Recommendation Report for Planning Permission for Works or Extension to a Dwelling

REF NO: FG/145/25/HH

LOCATION: 25 Clover Lane
Ferring
BN12 5LZ

PROPOSAL: Single storey side extension with new front porch.

Drawing Name:
Proposed Roof Plan

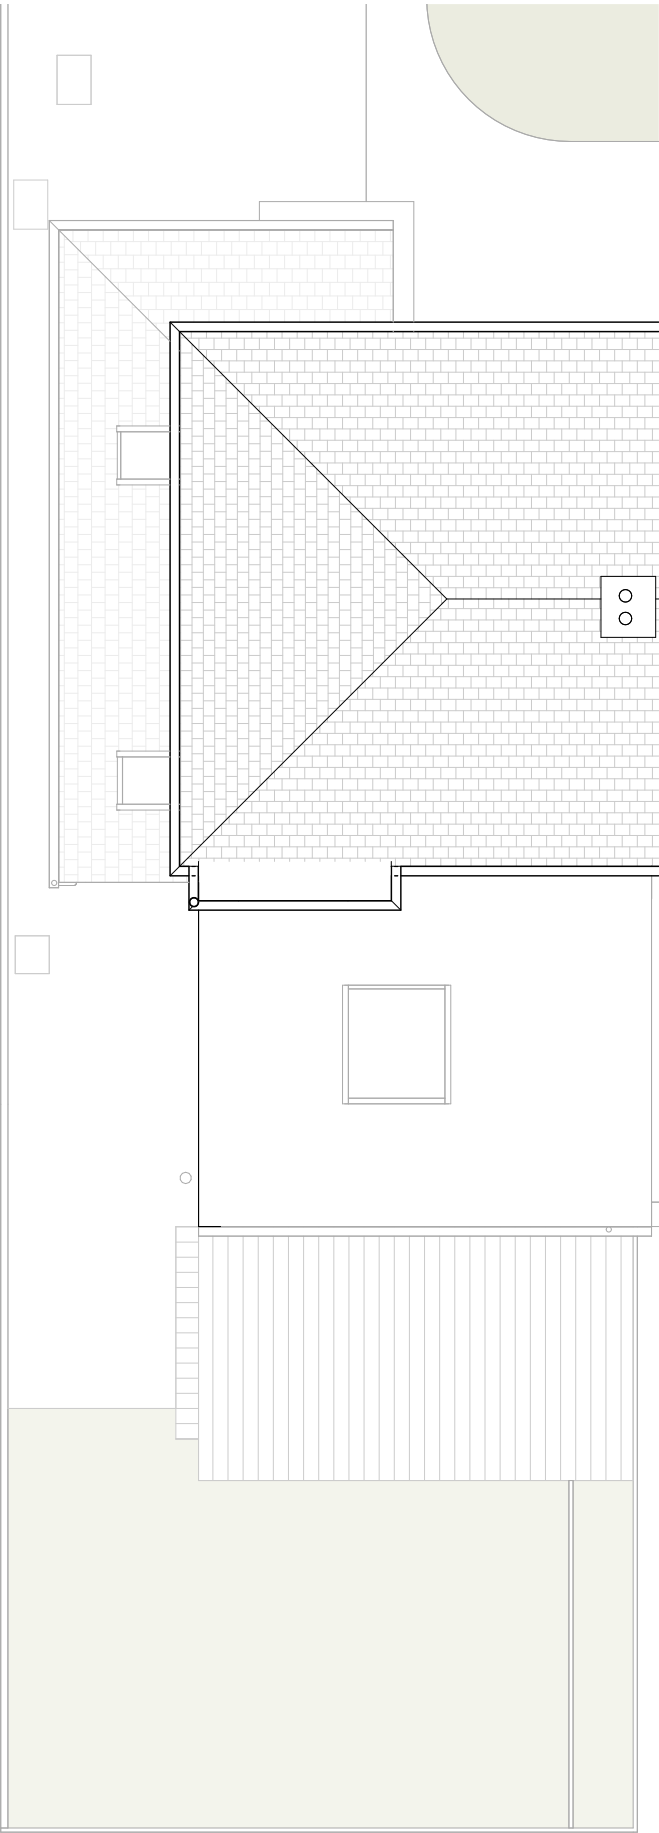
The single-storey side extension with new front porch would have a mono-pitched roof with a maximum approximate height of 3.8m and an approximate eaves height of 2.7m. On the side (west) elevation the mono-pitched roof would contain two rooflights positioned high in the roof slope, close to the abutment of the host dwelling.

Proposed Elevations

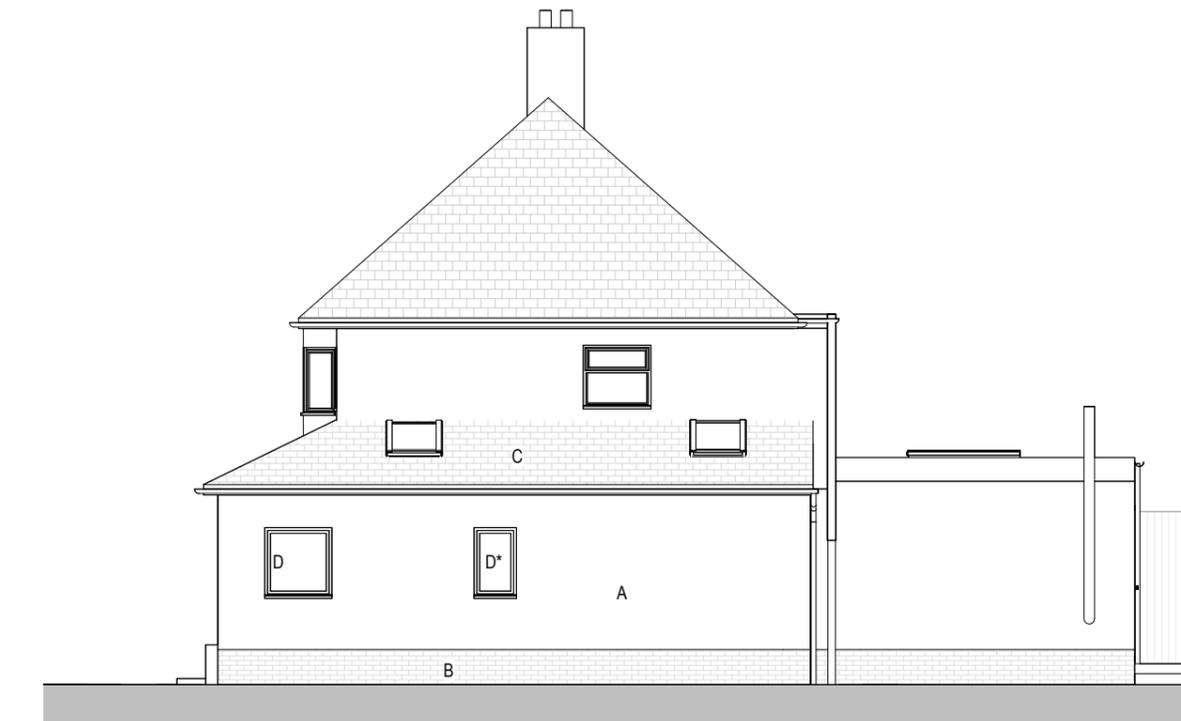
The single-storey side extension and new porch would be finished with brick work on the lower plinth, rendered walls and roof tiles to match the host dwelling. Fenestration to the front (north) elevation would be a single entrance door. Fenestration to the side (west) elevation would be two single double-glazed windows, with the central window being obscurely glazed. Fenestration on the rear (south) elevation would be a single double-glazed door.

Fenestration on the front (north) elevation would have an outlook of the front amenity serving the host dwelling and fenestration on the side (west) would have an outlook of existing high boundary treatment, with the central window being obscurely glazed as it would serve a downstairs toilet. Fenestration on the rear (south) elevation would have an outlook of the host dwelling's rear amenity. To accord with Arun Design Guide Part M any roof light located on the roof slope of a side elevation should use obscured glass, therefore a condition is attached to this planning permission to maintain the privacy of the neighbouring properties. On balance, the proposed single-storey side extension and new porch would not result in loss of privacy or overlooking to the neighbouring dwellings.

- 3 Any roof light located on the roof slope of a side (west) elevation shall at all times be and remain glazed entirely with obscure glass to a level equivalent to Pilkington Level 3 or nearest equivalent standard. This arrangement shall be retained permanently thereafter.
